WEST SUSSEX COUNTY COUNCIL CONSULTATION

TO:	Arun District Council FAO: Anita Gardner
FROM:	WSCC - Highways Authority
DATE:	2 October 2019
LOCATION:	Land adjacent to Church Farm Barn, Horsemere Green Lane, Climping, BN17 5QX
SUBJECT:	CM/36/19/PL Retention of replacement fencing & proposed replacement entrance gates. This application may affect the setting of a Listed Building.
DATE OF SITE VISIT:	01/10/2019
RECOMMENDATION:	Advice
S106 CONTRIBUTION TOTAL:	n/a

This retrospective application is for the retention of 1.8m high fence to site boundary on Horsemere Green Lane.

BLOCK PLAN.

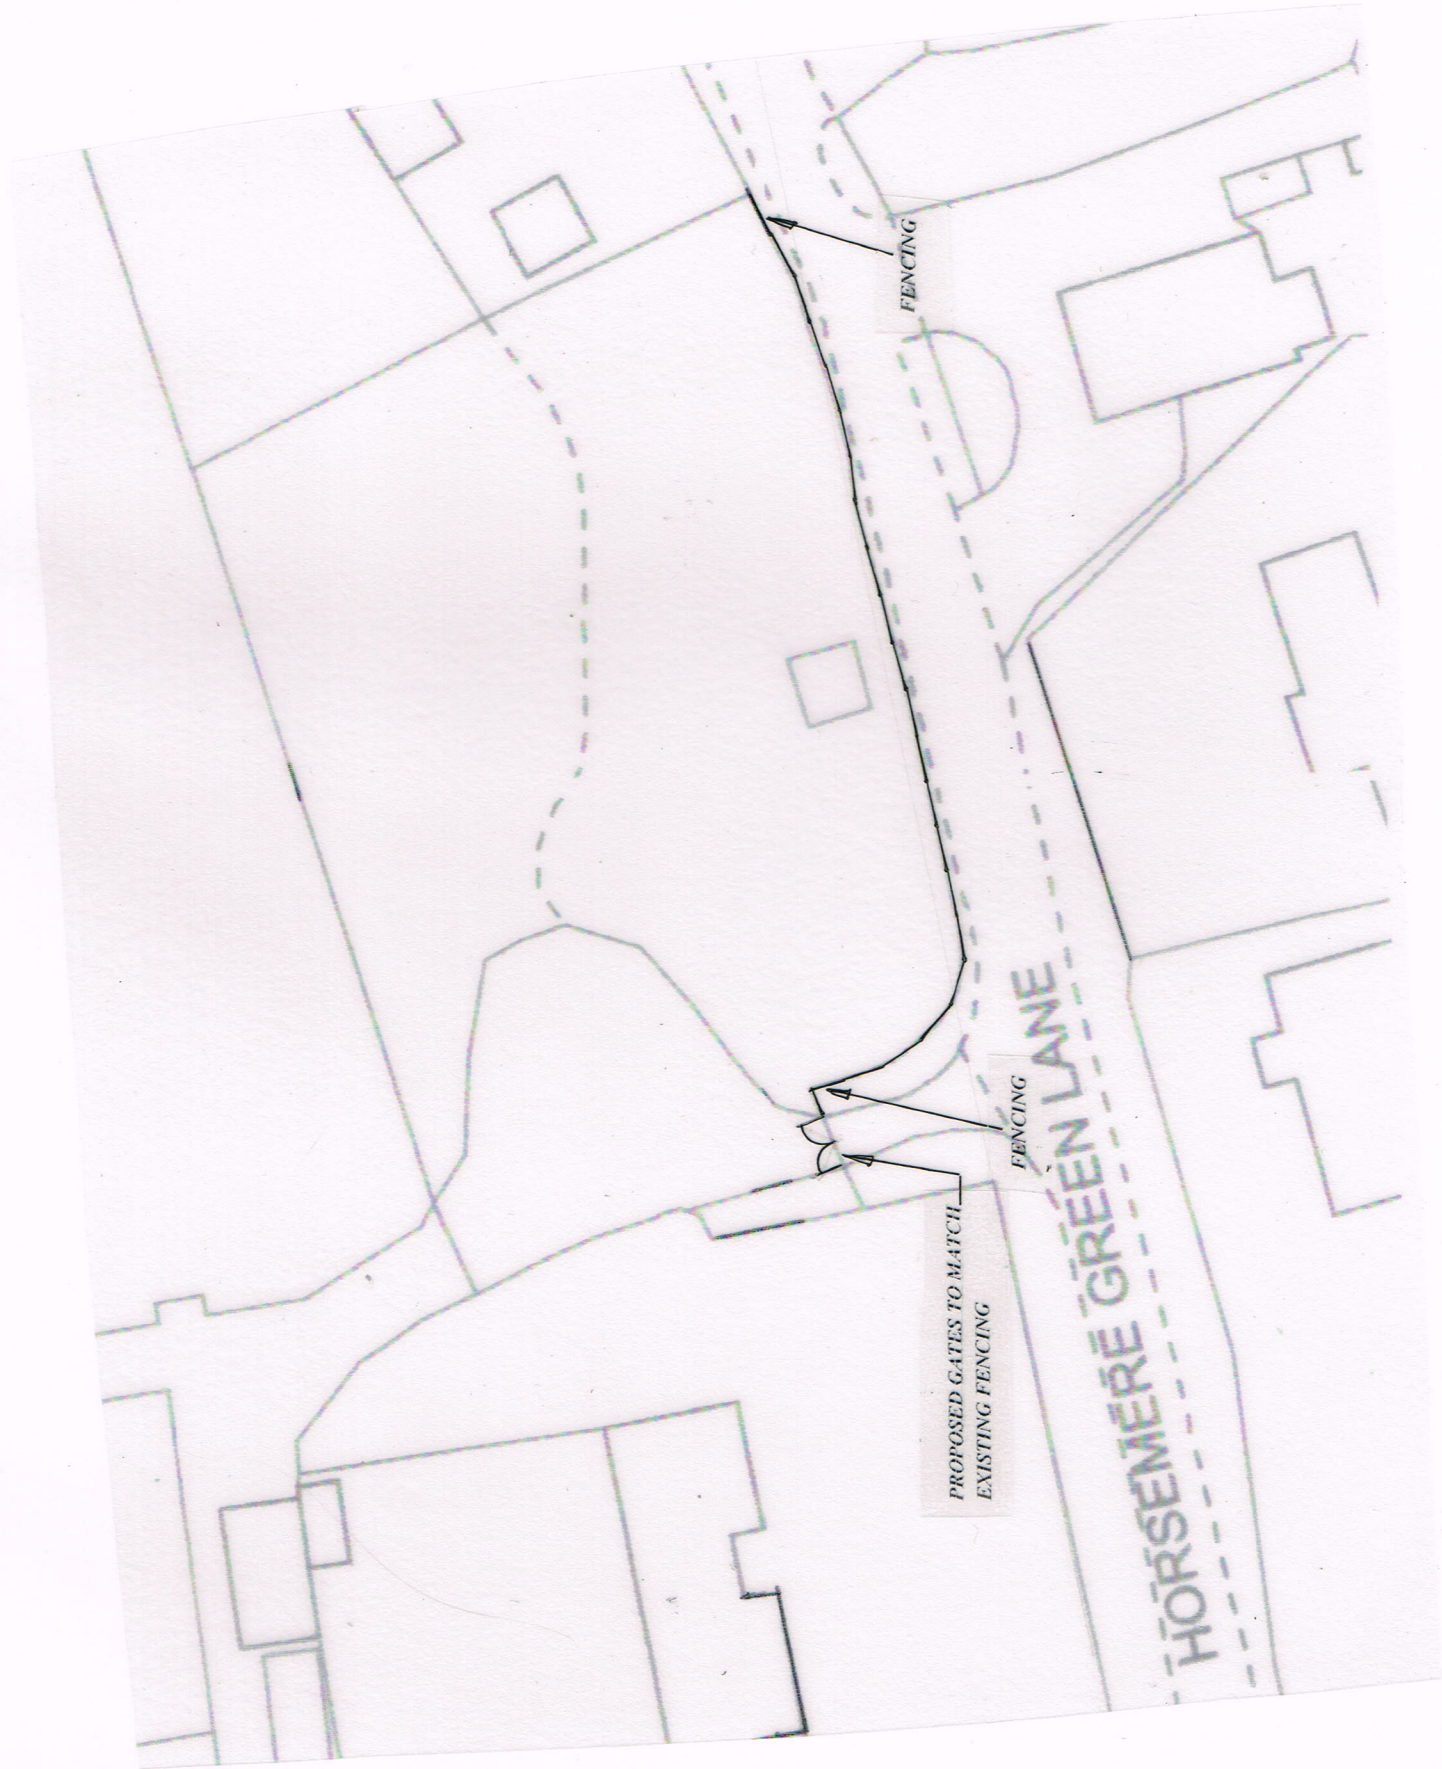
The LHA conducted a site visit on 1st October to determine whether the fence has been erected within the publicly maintained highway in this location. Following consultation with the Highway Boundary Officer, it was established that the publicly maintained highway is 1.5m in width for a length of 18m from the existing access. This then reduces to 1.5m in width for the next 42m until the boundary with Church Farm Cottages.

On site, it was observed that the fence has been erected within the public highway in this location. As such, the verge proposed to be incorporated forms part of the public highway. In order for the land to be incorporated into the site, the highway rights would need to be formally removed by way of a Stopping Up Order. Ordinarily, this is controlled by Section 247 of Town and Country Planning Act and would be subject to a separate process administered by the Department for Transport's National Casework Team. The Highway Authority along with other statutory undertakers and interested parties would be consultees in this process.

However, given the application is retrospective, if planning consent was to be granted, the development would only become lawful (and exempt from potential enforcement action) if the applicant successfully applies to 'Stop Up' the land, i.e. extinguish the highway rights. Retrospective Stopping Up would have to be undertaken via Section 116 of the Highways Act 1980, which involves an application to the Magistrates' Court for which they will have to pay. This is a legal process and there is no guarantee the stopping up will be successful, this can therefore not be secured via planning condition. Matters pertaining to highway safety and other highways considerations would be assessed at this stage.

The applicant should be aware that should the land in question not be stopped up, they could be liable to enforcement action from the Local Highway Authority. This would be via a separate mechanism to that of the planning process.

The LHA notes that the LPA has approved this application prior to Highways comments being provided. The applicant would be advised to seek Stopping Up as per the details above. Could the LPA make the applicant aware of this informative note regarding how to proceed with Stopping Up.

The applicant would be advised that to ensure the development is legal the land subject of this application considered to be publicly maintained highways should be formally stopped up via the appropriate legal mechanism. The applicant would be advised to contact WSCC Legal Services to find out further information about the Stopping Up procedure and how to commence an application.
